Subject: planning BE/92/20/DOC

I would like to address the Following For the above planning at the back of Babsham cottages as referenced above.

DRAWING TITLE
PROPOSED RESURFACING OF SITE ACCESS

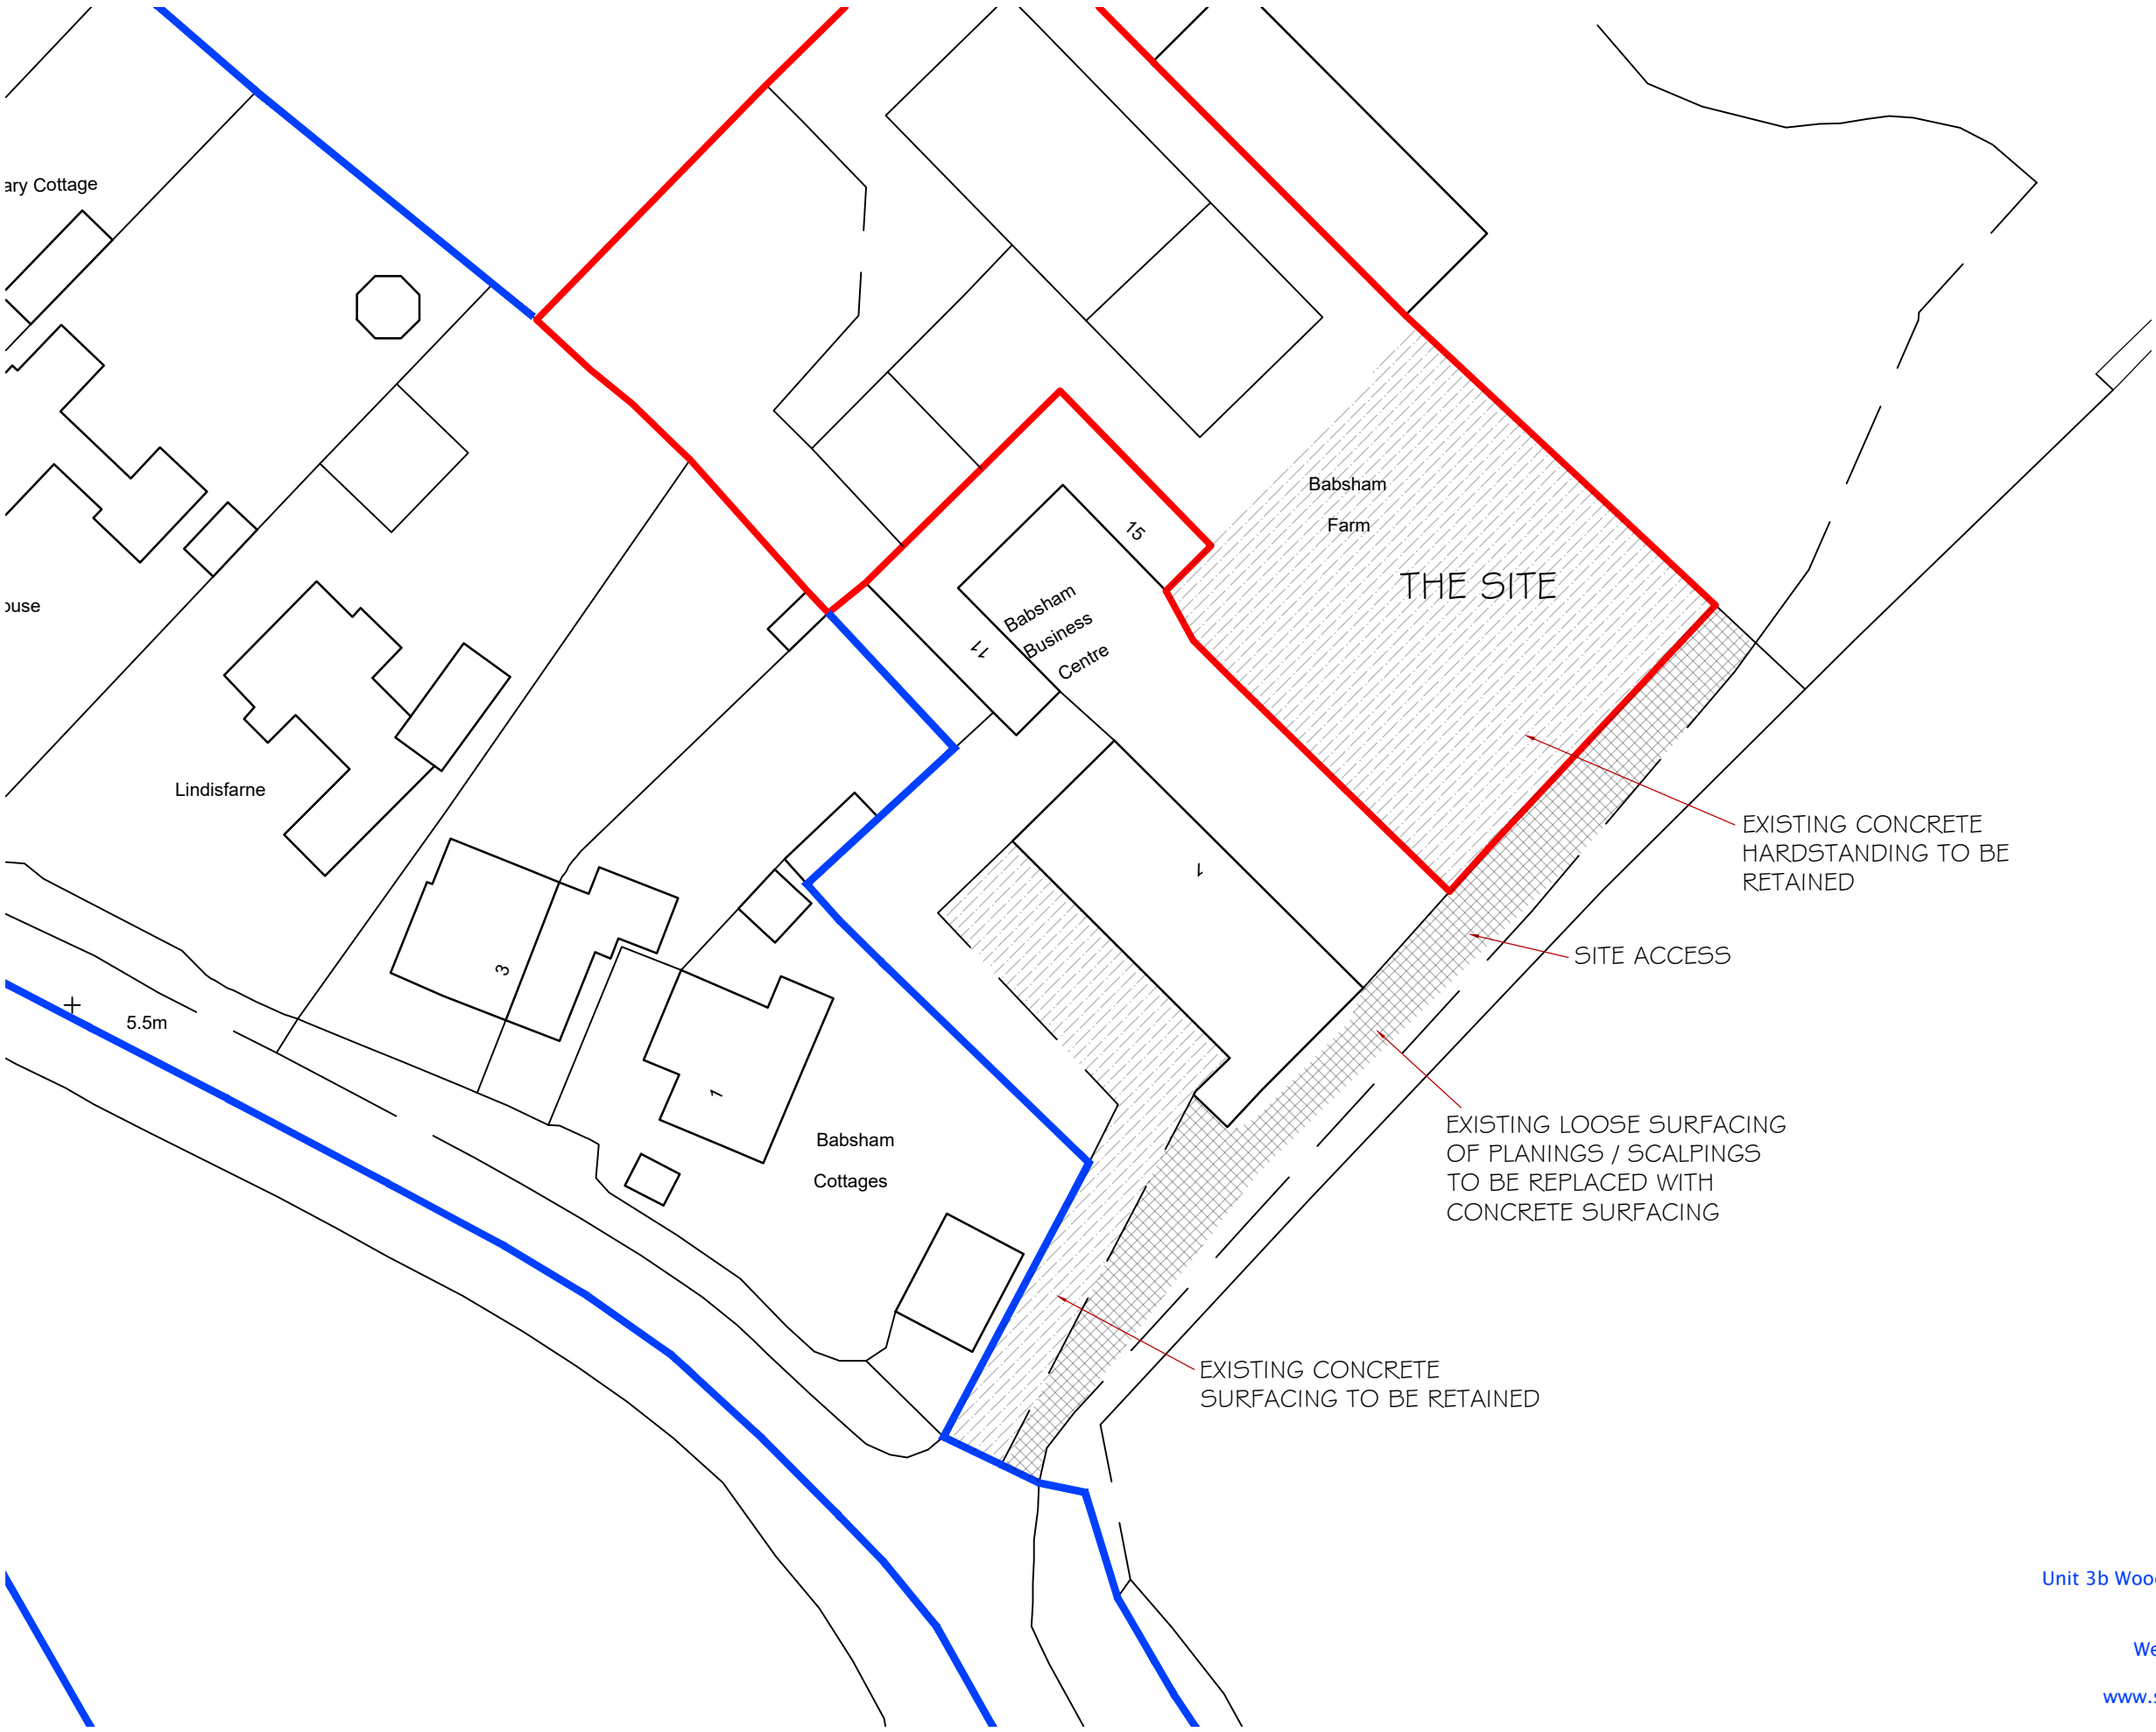
4) It seems that a concrete road will be constructed at the Entrance road to Babsham business centre. But does not take allowance for more

Vehicle's passing the front of about 4 properties where dust is a massive issue. E.g. cars and windows and the properties getting covered .

Although there is potential to use another track that needs upgrading this would stop lorries passing the properties and would also stop lorries crossing two lanes where it is a matter of time for an accident as there has been a few close calls. They would just turn left and be near a roundabout which they could go around which would decrease risk for an accident.

Figure 3: Survey Location

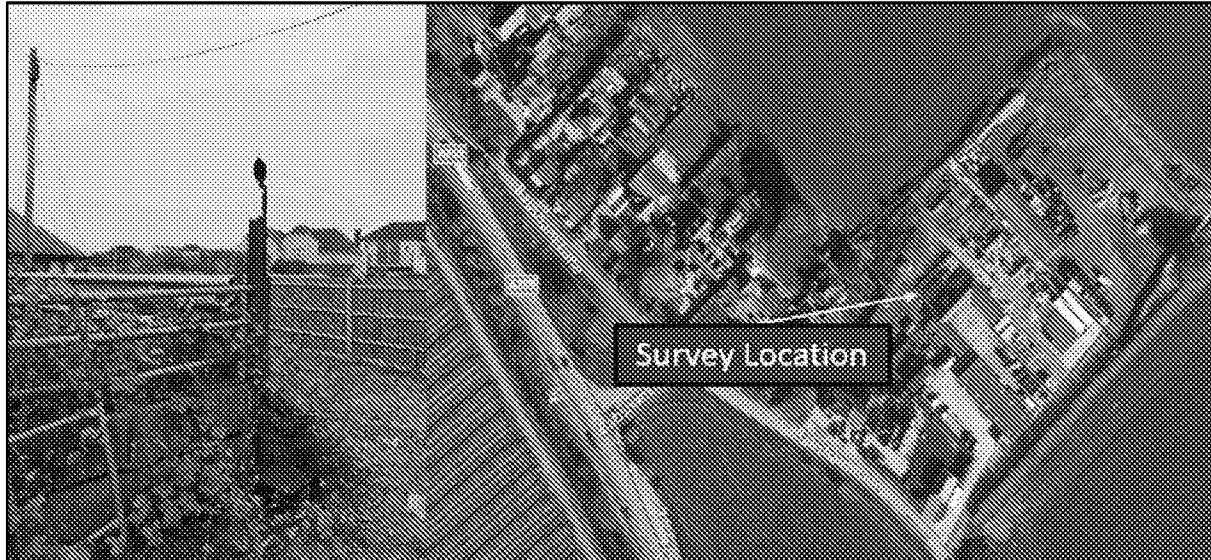
1) The microphone was stated at approximately 3 metres in height for the acoustic assessment and was at nearer 2.5 so not really close to 3 metres in height.
